Our Case Number: ABP-317121-23

Re: BusConnects Swords to City Centre Bus Corridor Scheme
Swords to Dublin City Centre

ABP case ref: 317121

BUSCONNECTS SWORDS CORE BUS CORRIDOR SCHEME

Drawing Title: **SWORDS TO CITY CENTRE CORE BUS CORRIDOR SCHEME JUNCTION SYSTEM DESIGN SWORDS ROAD / TURNAPIN LANE JUNCTION**

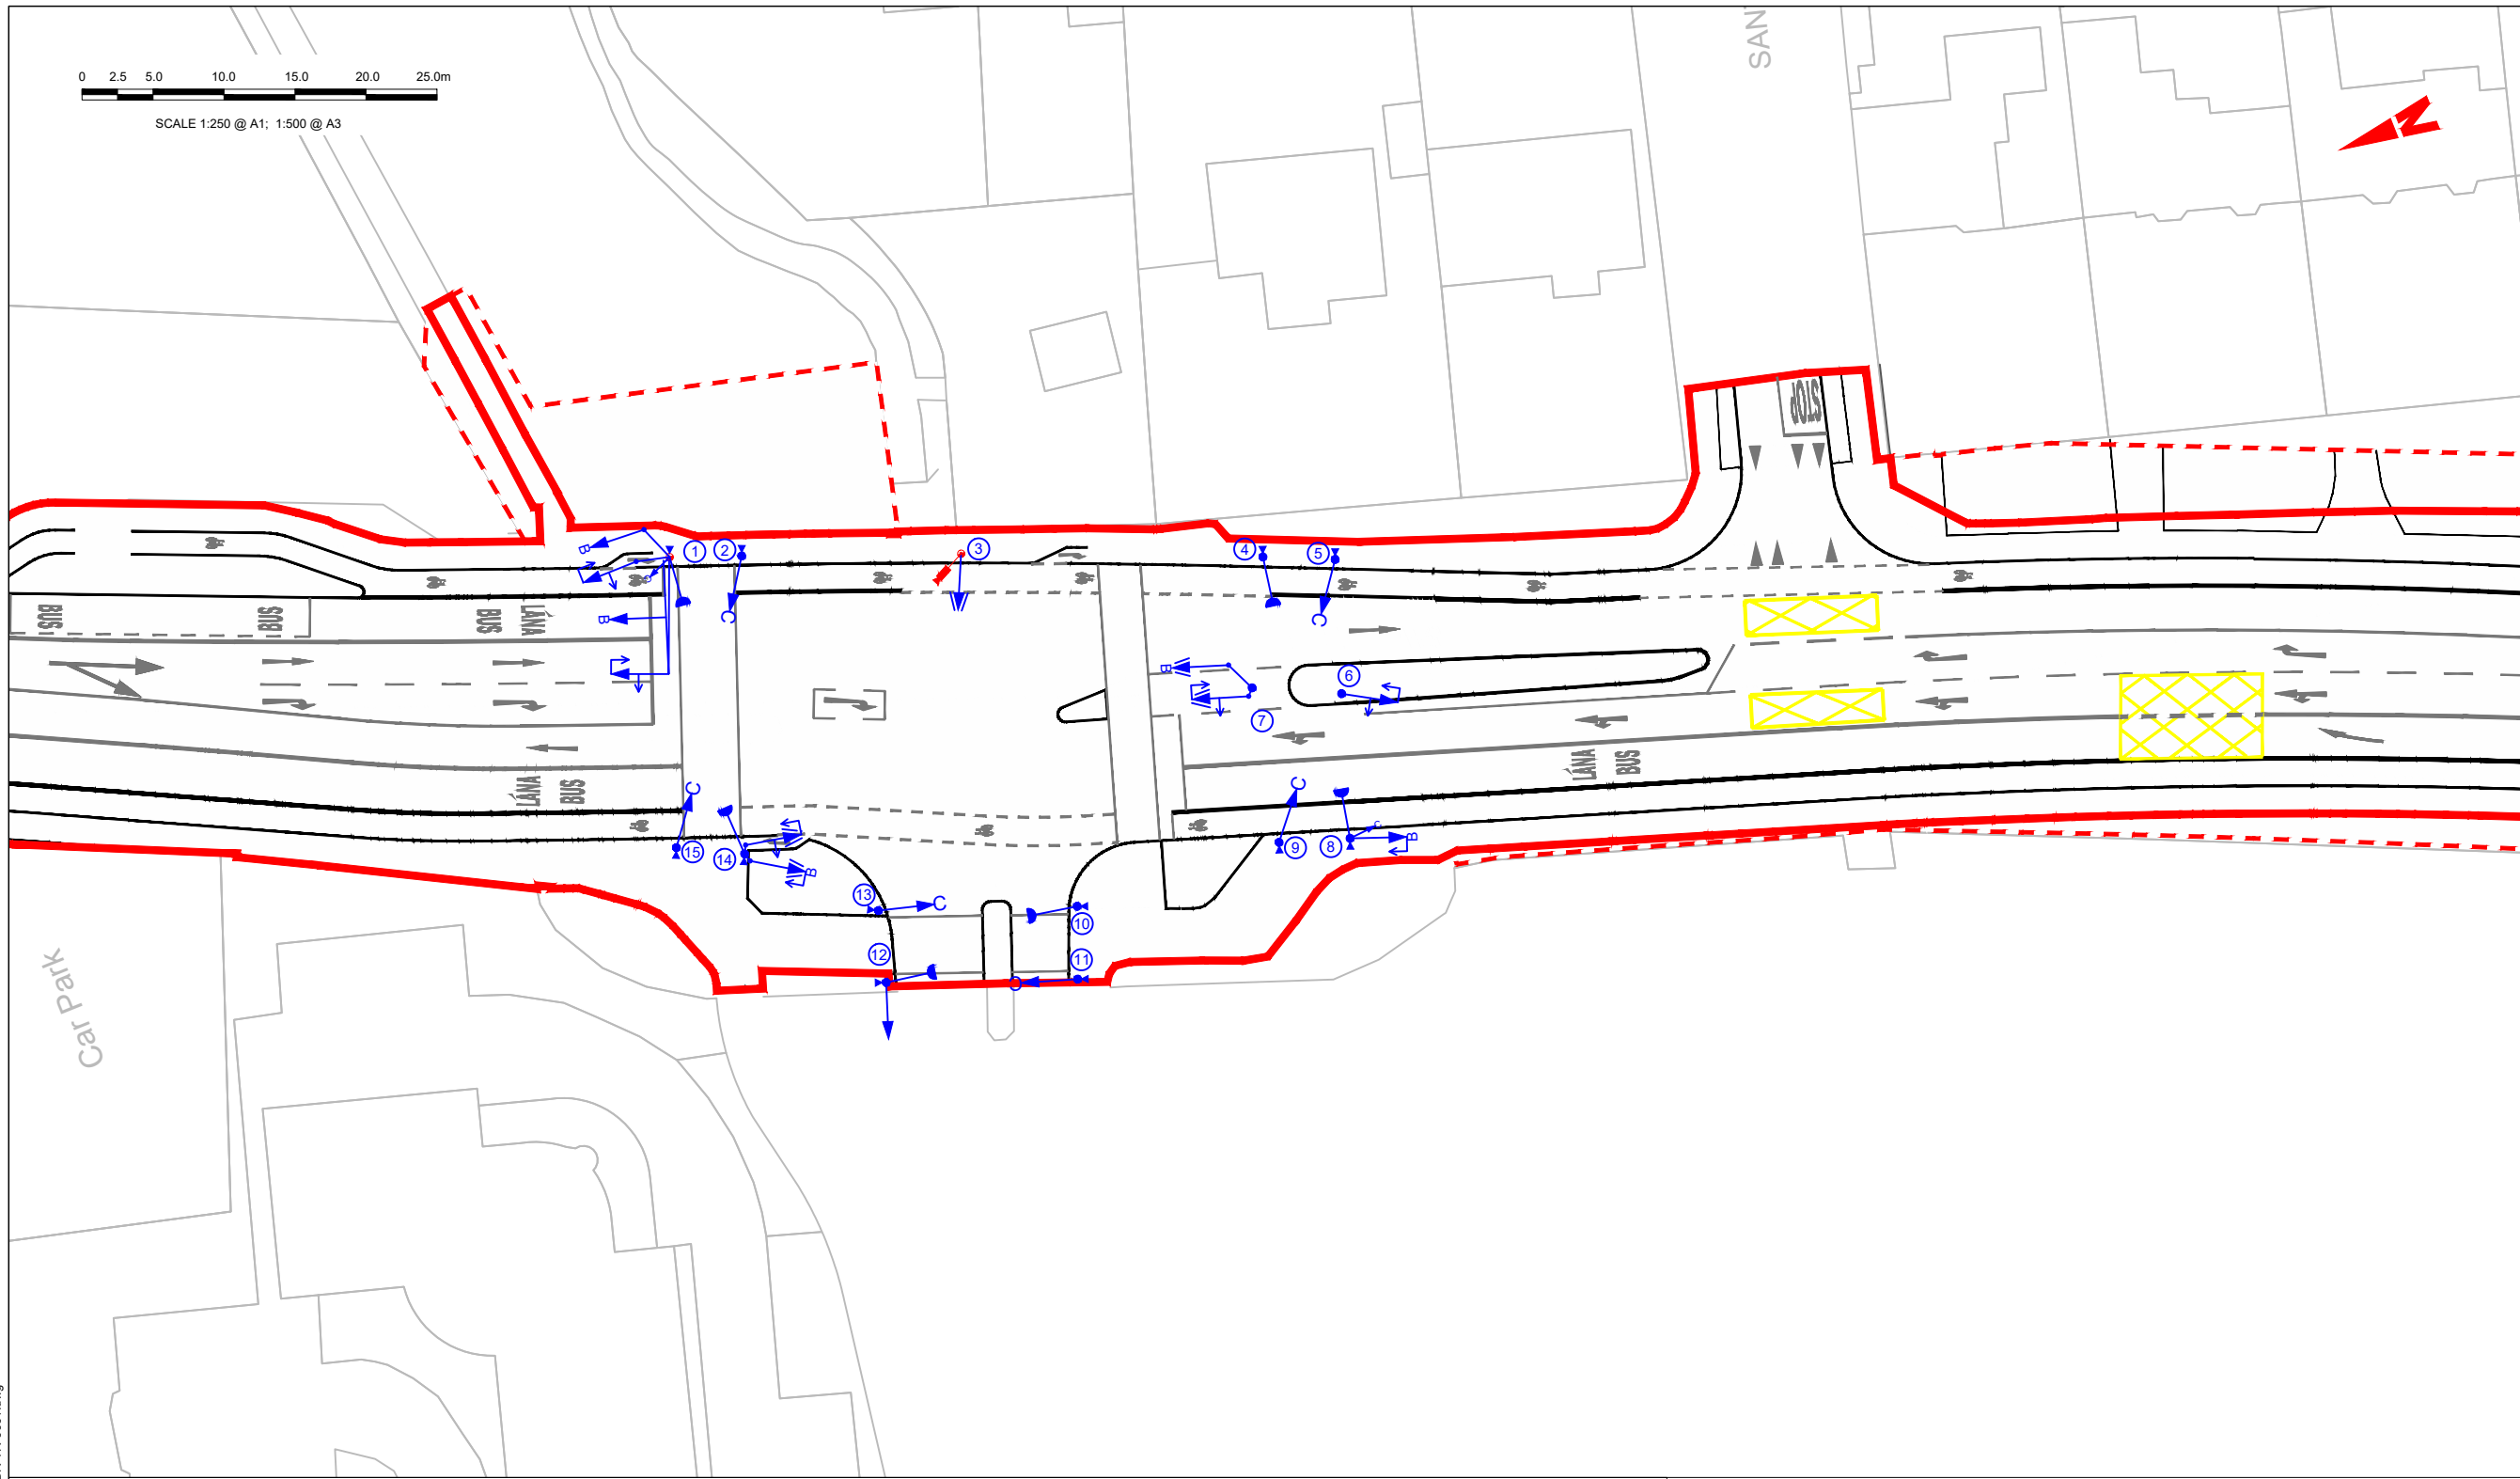
There are examples of two-stage pedestrian crossings proposed as part of this scheme. These crossings drastically increase the time required for pedestrians to navigate junctions and crossings. Section 4.4.3 Junction Design of the Design Manual for Urban Roads and Streets states that “designers should omit staggered crossings in favour of direct/single phase crossings” and Section 4.3.2 Pedestrian Crossings states that “designers should allow pedestrians to cross the street in a single, direct movement” and that “where staggered/staged crossings currently exist they should be removed as part of any major upgrade works”.

The following two-stage pedestrian crossings are clearly inconsistent with the Design Manual for Urban Roads and Streets:

- Turnapin Lane (15)
- Coolock Lane (18)
- Santry Ave (19)
- Omni Shopping Centre (20)
- Collins Ave (25)
- Griffith Ave (28)
- Clonliffe Rd (33)
- Whitworth Rd (33)
- North Circular Rd (34)
- Gardiner St Upper (34)

Figure 1 Example of two stage pedestrian crossings at Turnapin Lane
